**KIRKLEES METROPOLITAN COUNCIL
INVESTMENT & REGENERATION SERVICE**

DELEGATED DECISION TO DETERMINE PLANNING APPLICATIONS

Reference No:	2026/62/91583/E
Site Address:	215, Cumberworth Lane, Lower Cumberworth, Huddersfield, HD8 8PR
Description:	Erection of front porch and first-floor balcony
Recommending Officer:	Joanna Rednall

DECISION – Conditional Full Permission

title:  
Proposed Elevations

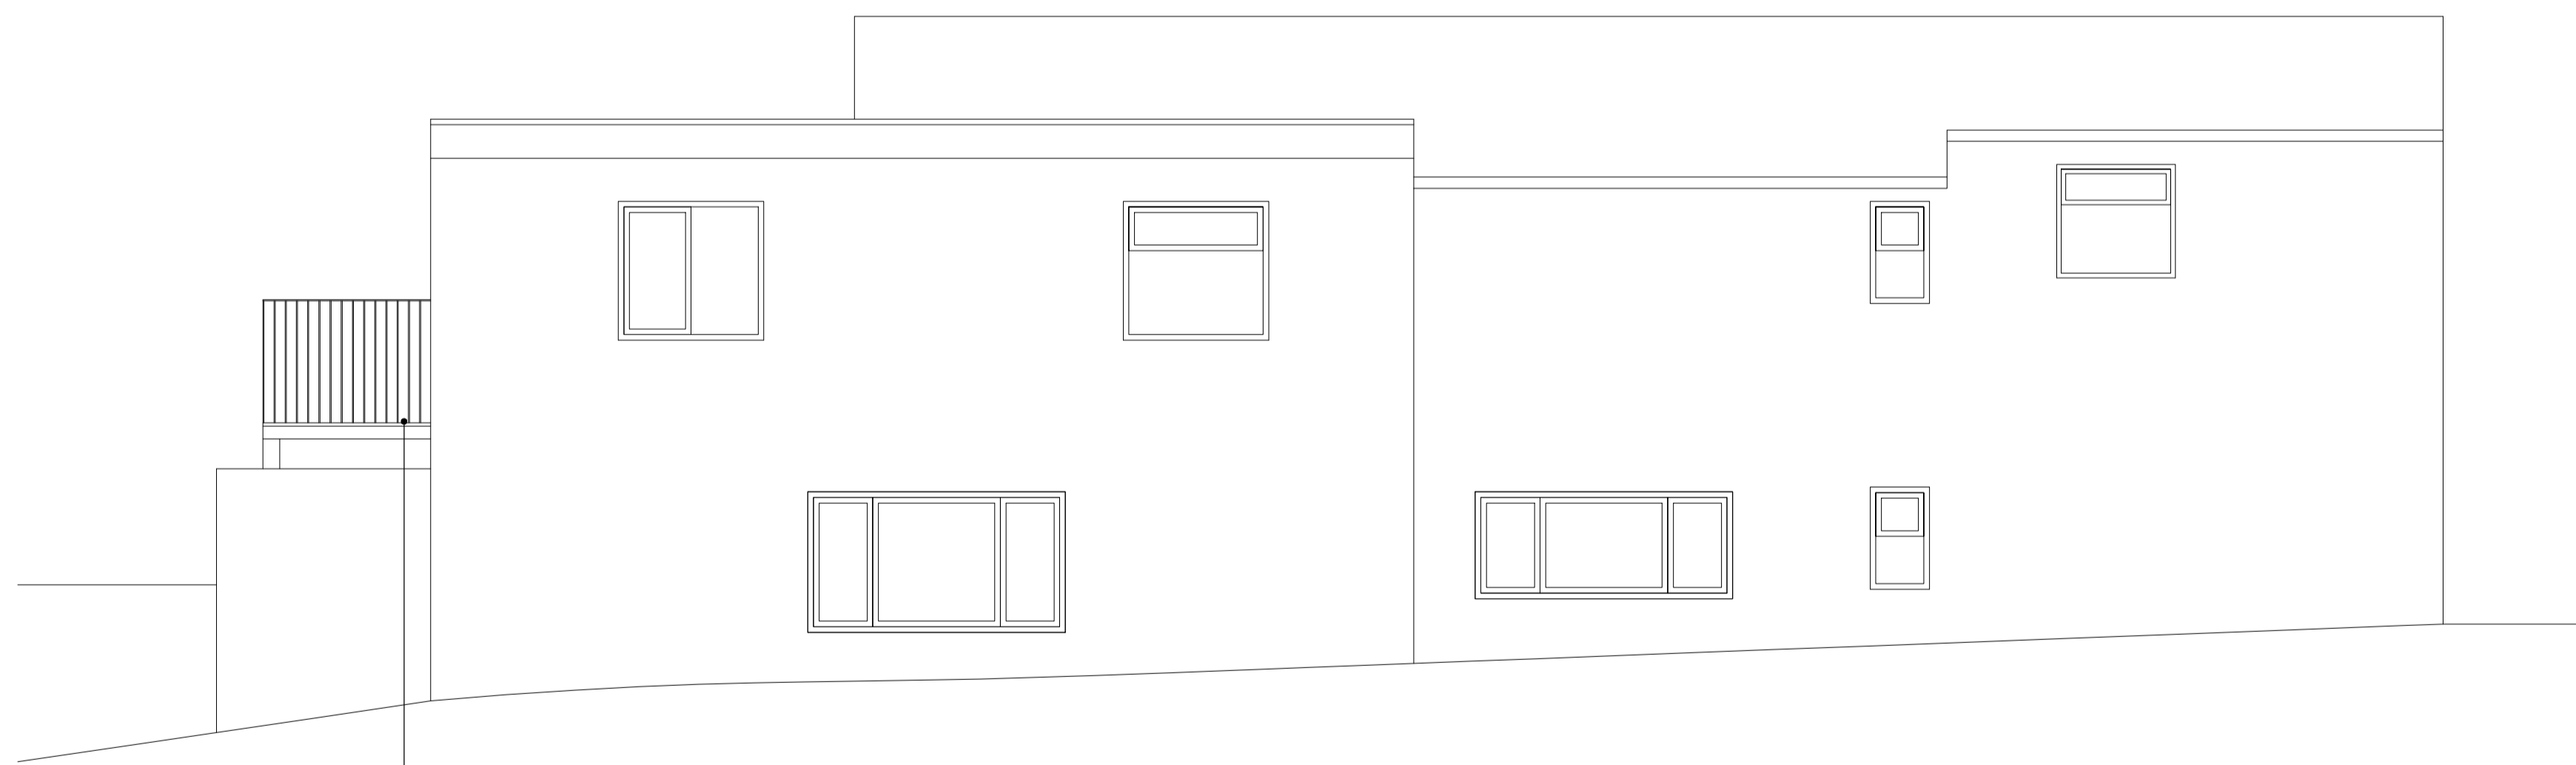
The proposed porch is located on the front/east-facing elevation and measures approximately 1.1m in depth and 2.3m in width, with a height of 1.8m to the eaves and 3.1m to the ridge. The porch would be of timber-frame construction with a pitched roof finished in slate.

The proposed balcony is located on the north-facing elevation and measures 2.3m in width, projecting 1.5m from the external wall. The balcony would be raised approximately 2.3m above external ground level and supported on a timber frame. A 1.1m-high steel balustrade would be provided around the perimeter of the balcony.

In this case, the proposed porch would be located on the front elevation, where the SPD advises that front extensions should have regard to the guidance set out in paragraphs 5.13 and 5.14. The porch would be set well back from the pavement and would be largely screened from the highway. The elevation faces away from the highway and is further screened by the existing hedge, meaning the porch would have limited visibility and would not appear prominent within the public realm. It is modest in scale, with a limited projection and width, and would remain clearly subservient to the host dwelling.

The porch would be of an open timber-frame construction with a pitched slate roof, with the slate finish matching the existing roof materials of the dwelling. Given its modest scale, simple form and appropriate materials, the porch would read as a subordinate addition to the host property. It is therefore considered that the proposal would integrate satisfactorily with the existing dwelling and would not result in harm to the character or appearance of the street or the wider local area.

Turning to the proposed first-floor balcony, this would also be modest in scale, measuring approximately 1.5m in depth and 2.3m in width. Its limited size and footprint would ensure that it remains subordinate to the host dwelling and would not appear overly prominent or dominant within the elevation. The balcony would be accessed through an enlarged first-floor window opening and would be visible from wider public vantage points along Cumberworth Lane. However, given its modest scale, height and lightweight form, it would not appear unduly prominent or result in harm to the character and appearance of the dwelling or the wider street scene. It would be constructed with a timber frame to match the proposed porch, together with a steel balustrade, resulting in a simple and lightweight addition that would sit comfortably with the existing dwelling.

The proposed balcony would be elevated approximately 2.3m above external ground level and, as such, has the potential to introduce additional opportunities for overlooking. However, the balcony would not be directly orientated towards No. 217 and would be positioned approximately 19m from its side elevation. The principal outlook from the balcony would instead be

towards the open fields to the north of the site. Furthermore, a site visit confirmed that the west-facing elevation of No. 217, which faces towards the application site, is blank. The principal private amenity space associated with No. 217 is located to the east of the property and would therefore be screened from direct views from the proposed balcony. On this basis, it is considered that the balcony would not result in a significant or unacceptable overlooking relationship or otherwise harm the privacy or amenity of neighbouring occupiers.
